CITY OF PORTLAND

August 18, 1999

RE: 27 Copley Wood Circle (lot#6) 413-B-006
31 Copley Wood Circle (lot #7) 413-B-007
R-3 PRUD Development

# 27 COPLEY WOODS CIRCLE

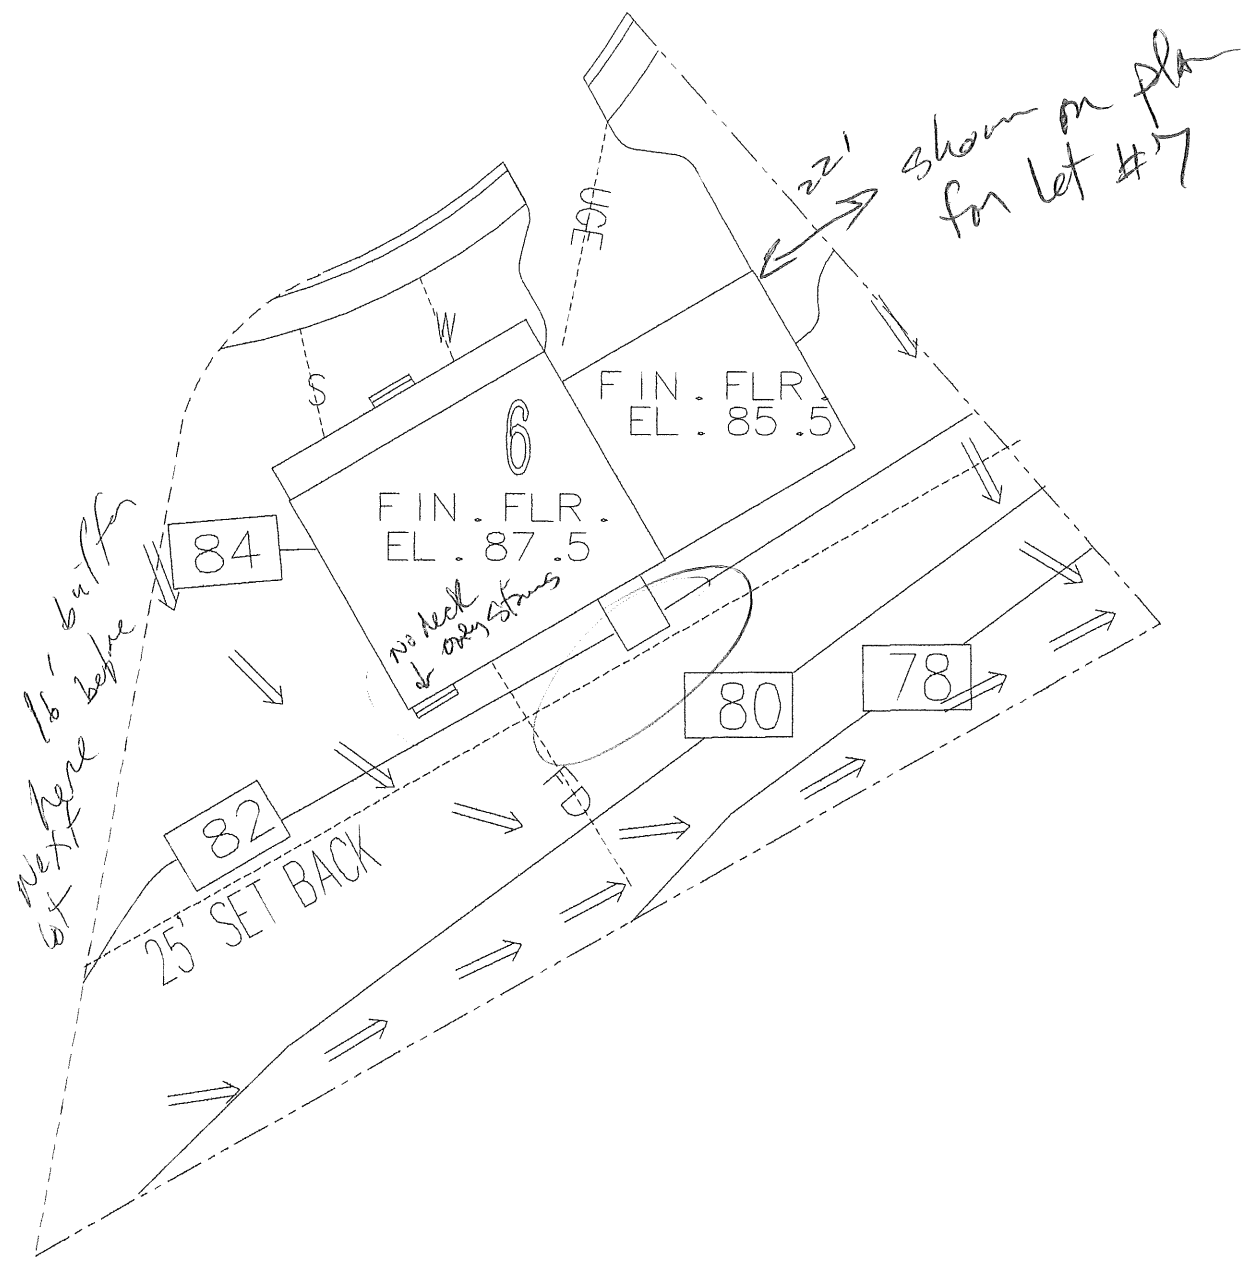
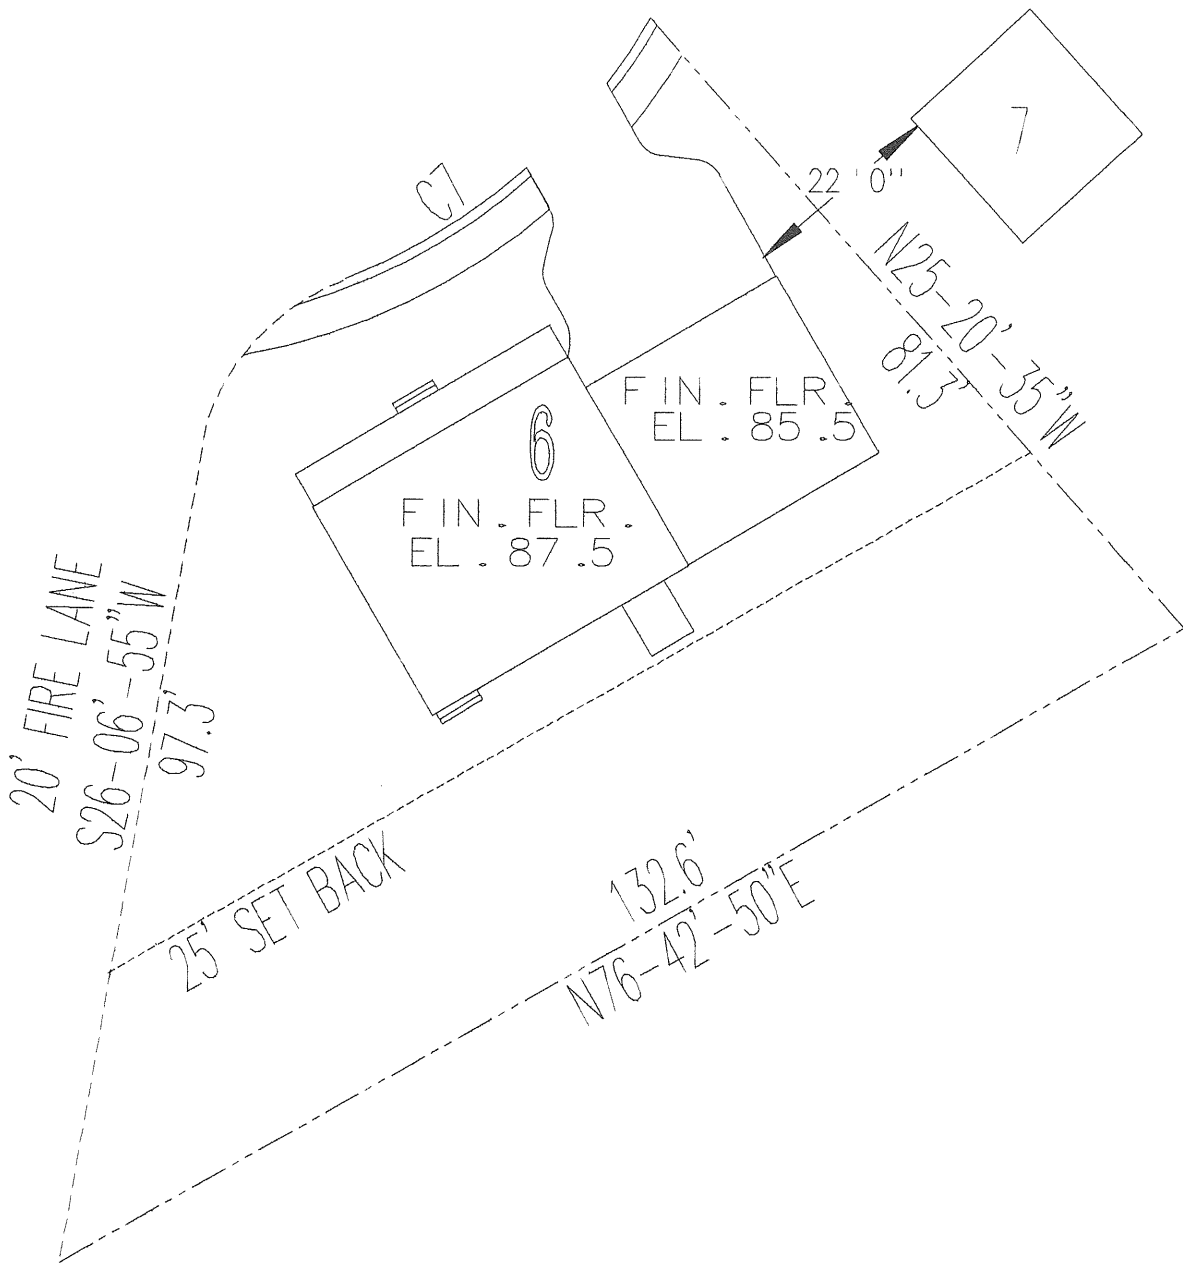
27 Copley Wood Circle (lot #6) The structural plans and the plot plan do not match. The house and garage appear to be reversed from one another on each plan. The house plan also shows a simple front door with a small deck and steps to the ground. In magic marker scrawled in is "4' x 32' farmers porch". The plot plan shows a porch the length of the house. I should not have to choose or guess what plan is being used. You need to show us exactly what you intend to build so that we can properly review your plans for compliance.

# 31 COPLEY WOODS CIRCLE

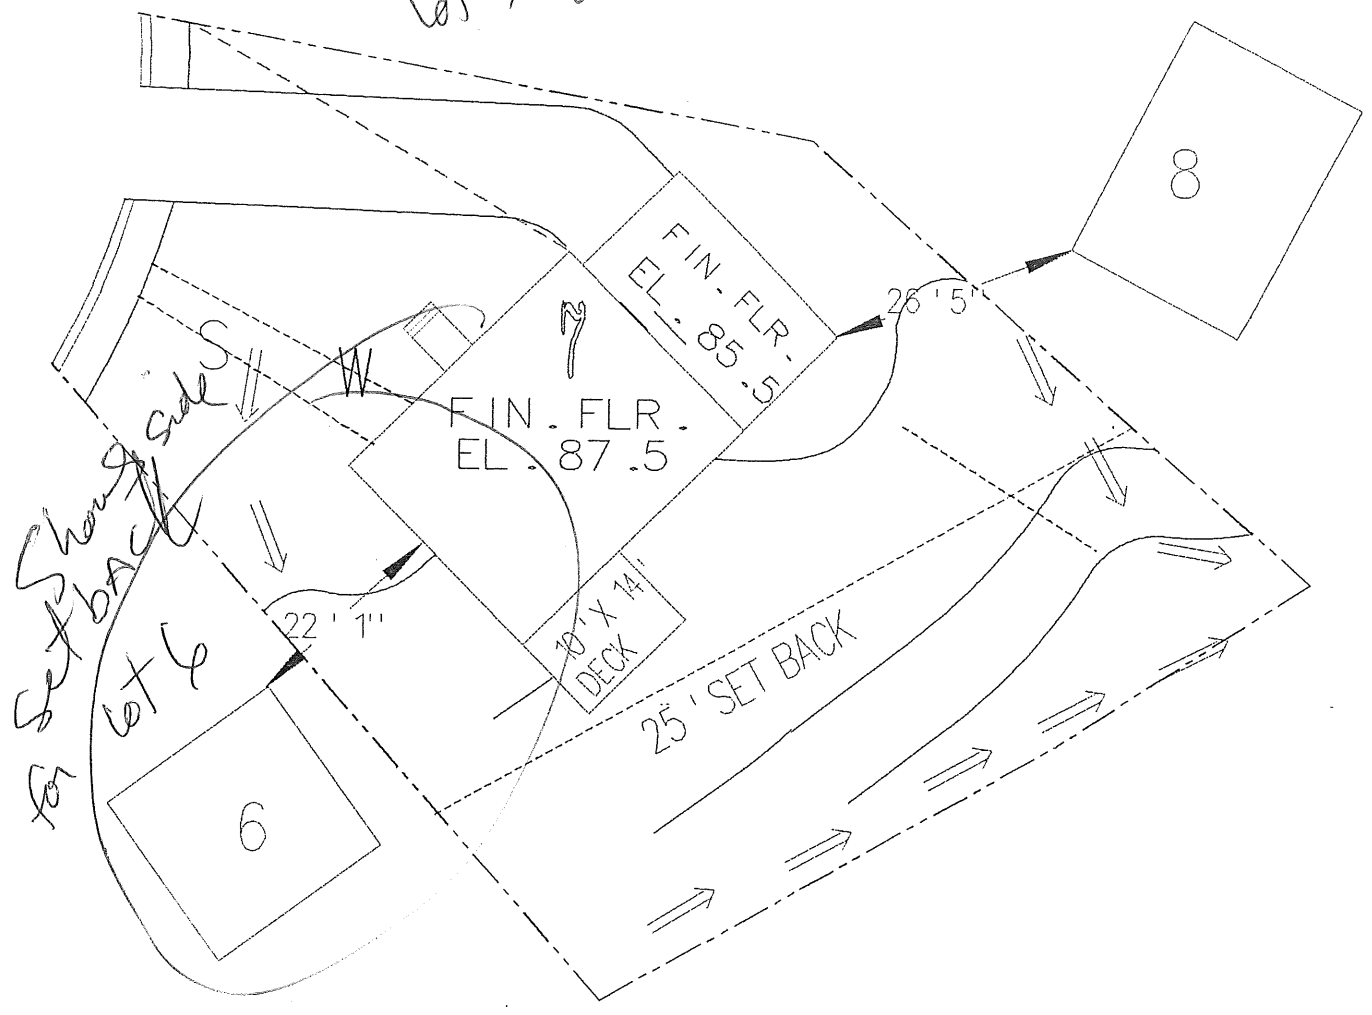
31 Copley Wood Circle (lot #7) Again the structural plans and the plot plan do not match. The house and garage appear to be reversed from one another on each plan. Since 16 feet is required between detached PRUD units, I need to see the house footprint location on lot #8 on your submitted plot plan to insure that the side setback requirement between structures is being met. The most serious problem I have is, if I have guessed right, the bulkhead that you have propose on the rear of the house would project into the 25 foot required setback from the external property line. As I have measured, you would have a 22 foot setback instead of the required 25 foot. This bulkhead projection is not shown on your plot plan. It is required to be shown accurately on your plot plan. That issue also must be resolved before the issuance of this permit.
